From: Sue Howell
Sent: 31 January 2017 14:24
To: Planning.Responses
Cc: David Easton
Subject: RE: Planning Consultation on LU/355/16/DOC

Comment from Greenspace

APPLICATION NO: LU/355/16/DOC

Registered: 09-JAN-17
Site Address: Land North of 7-12 Joyce Close Littlehampton
BN17 7JG

Drawing Number: TND 26561-2A

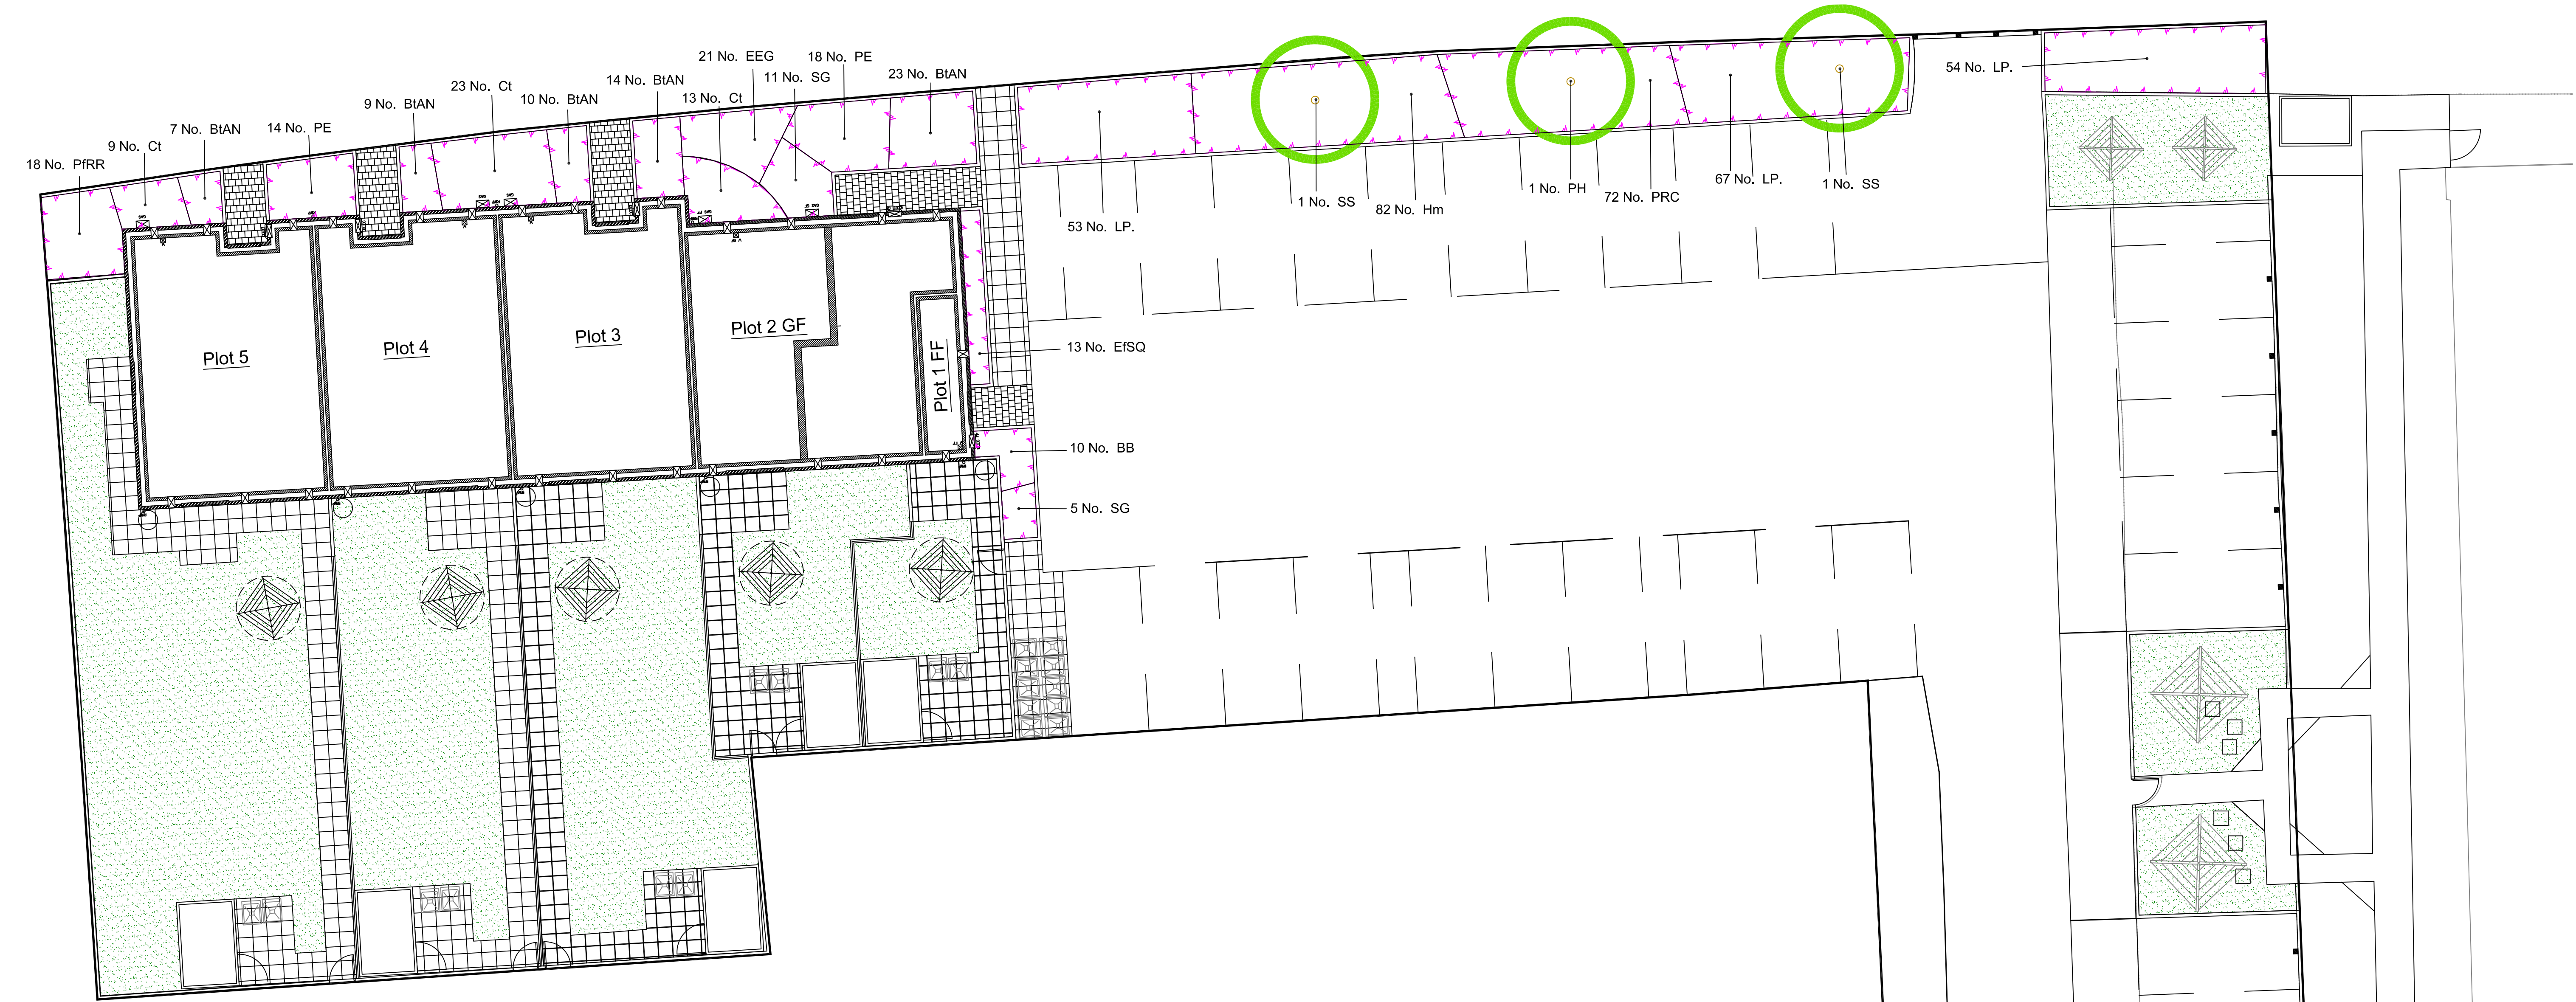
Further to submission of VDW 'planting drawing' dated Nov 2016, we can confirm that the information supplied does propose a well thought out and comprehensive scheme which is fitting for location and therefore we would recommend the discharge of Condition 6 Landscaping scheme reserved under planning approval LU/222/14/PL on this application LU/355/16/DOC.
